From: Anthony.Collier@hertfordshire.gov.uk
Sent: 19 March 2018 09:17
To: Planning
Subject: Planning application 6/2018/0291/HOUSE - 44 The Ridgeway

Response to Planning application from Hertfordshire County Council (T and CP GDP Order 2015)

District ref: 6/2018/0291/HOUSE

Erection of a double storey side and single storey rear extension, front porch with access, driveway and frontage alterations

| PROPOSED ACCESS PLAN | TDC027/PL/302   |       |

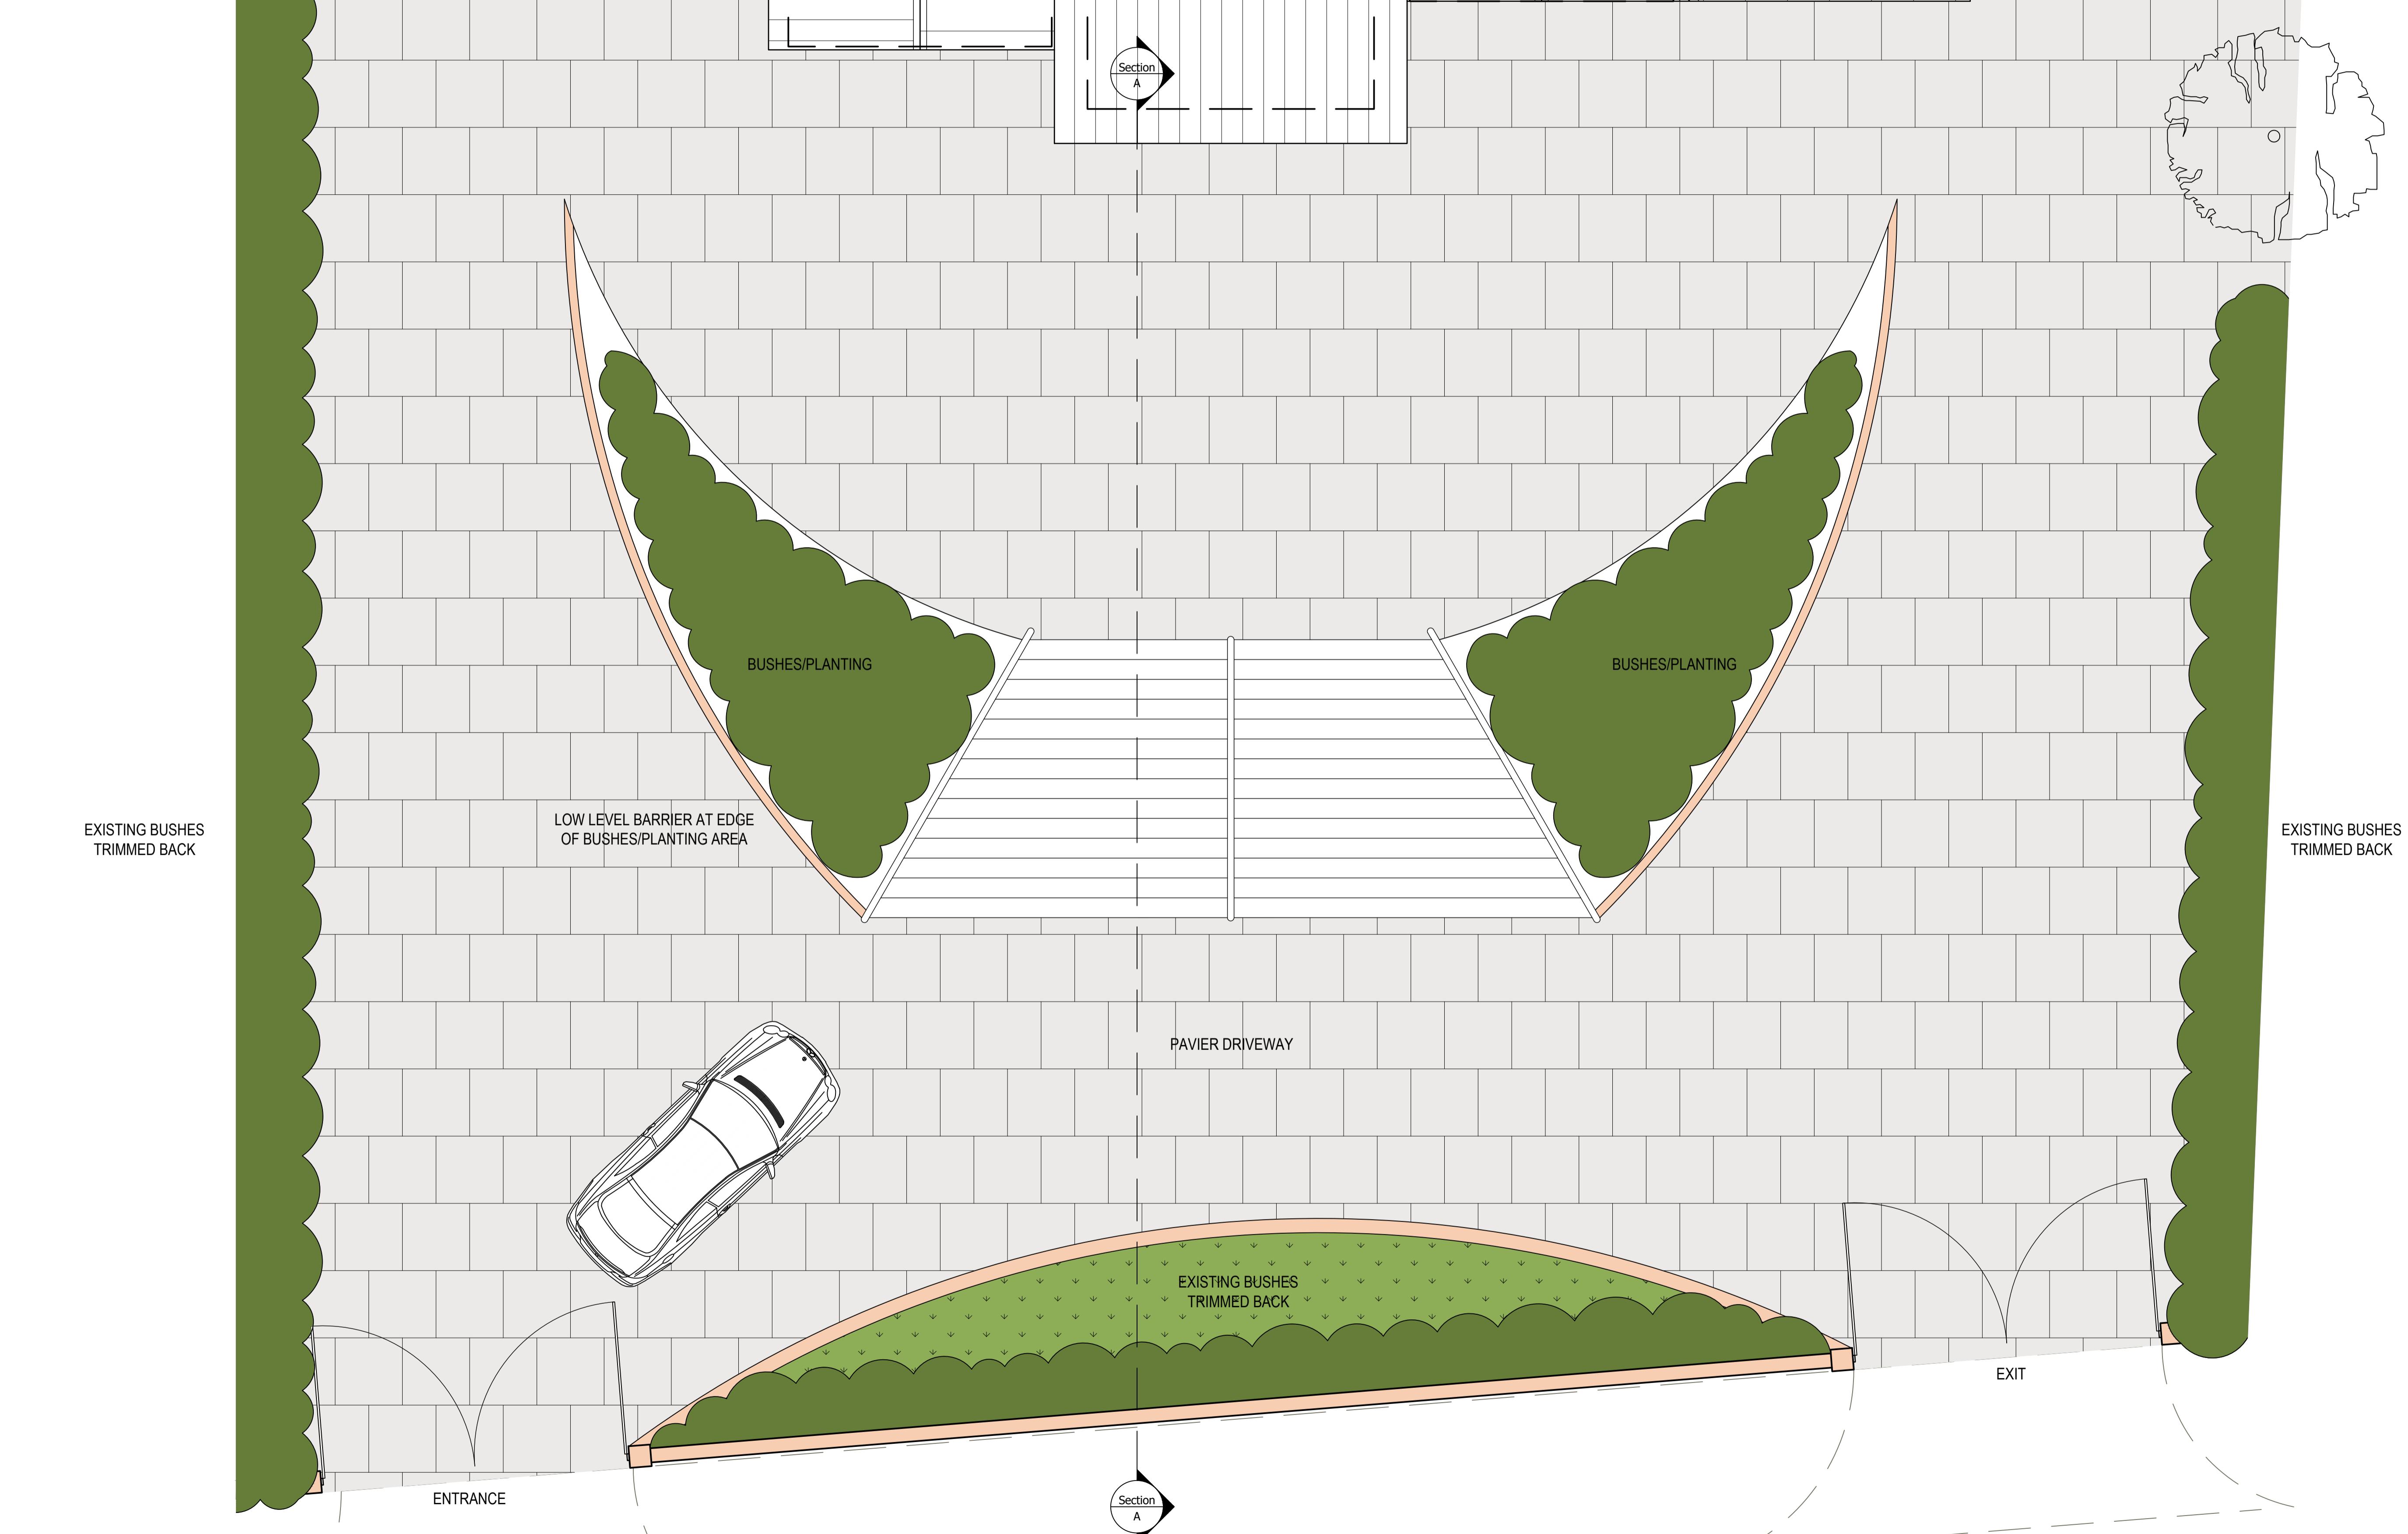
Prior to the first occupation of the development hereby permitted any access gate(s), bollard, chain or other means of obstruction shall be hung to open inwards, set back, and thereafter retained a minimum distance of 6 meters from the near channel edge of the adjacent carriageway . Any sidewalls / fences / hedges adjacent to the access shall be splayed at an angle of 45 degrees from each of the (outside) gateposts to the front boundary of the site

The application for state4s that amendments to the access form the public highway are proposed, upon review this does not appear to be the formation of any additional accesses to the site, with the site having two vehicle access points currently. it would appear minor works are proposed including the addition of gates to the access. Due to the nature of The Ridgeway and its function as a secondary distributor road, it is conditioned that the gates be a minimum of 6 meters from the carriageway nearside edge, so as to ensure vehicles can fully draw off of the carriageway, as there is no footway this is unlikely to impede pedestrians.
